Cc: Jamey Ayling <jamey.ayling@co.kittitas.wa.us>; Ellie Myers <ellie.myers@co.kittitas.wa.us>; Bradley Gasawski <bradley.gasawski@co.kittitas.wa.us>
Subject: VA-25-00004 Jones - Notice of Application

CDS is requesting comments on the following setback variance application: VA-25-00004 Jones.

TO: All Staff
FROM: Public Works Plan Review Team
DATE: August 4, 2025
SUBJECT: VA-25-00004 Jones

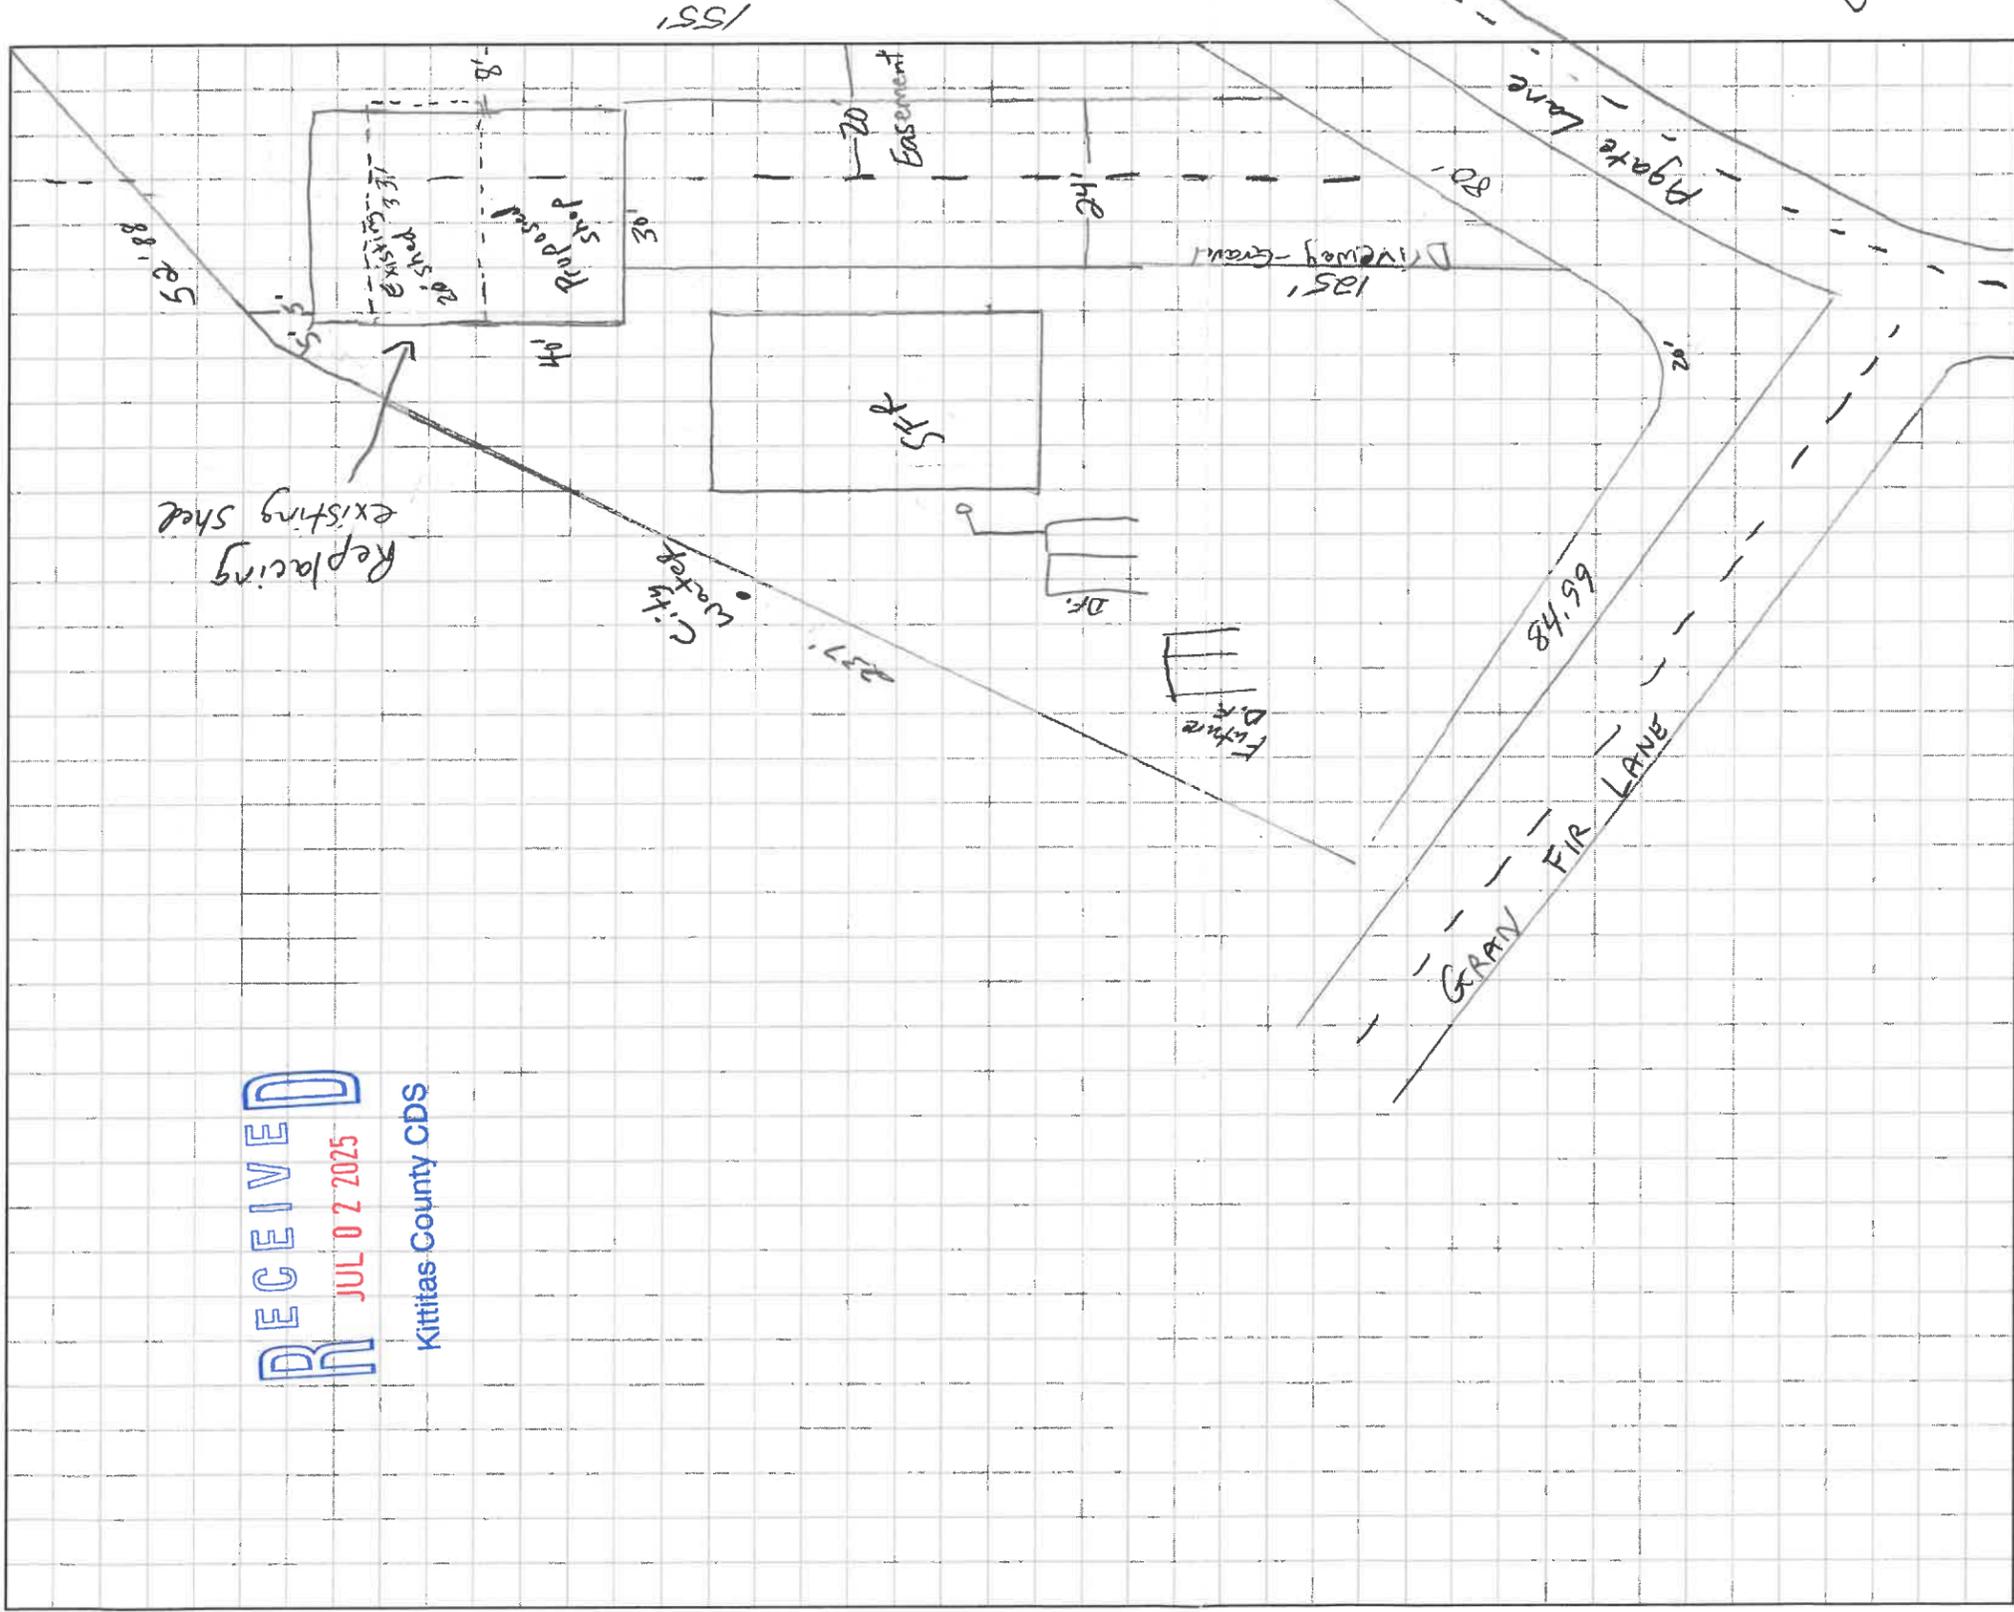
SURVEY	1. The proposed shop expansion falls on an existing 20' wide easement (per Survey 201806200044). The easement shall need to be vacated prior to approval, unless the purpose of the easement specifically would not be impacted by a building OR unless specifically approved by the Building Official. (JT)
TRANSPORTATION CONCURRENCY	No Comments.
FLOOD	No comments. (SC)
WATER MITIGATION/ METERING	No comments. (SC)
AIRPORT	No Comments.
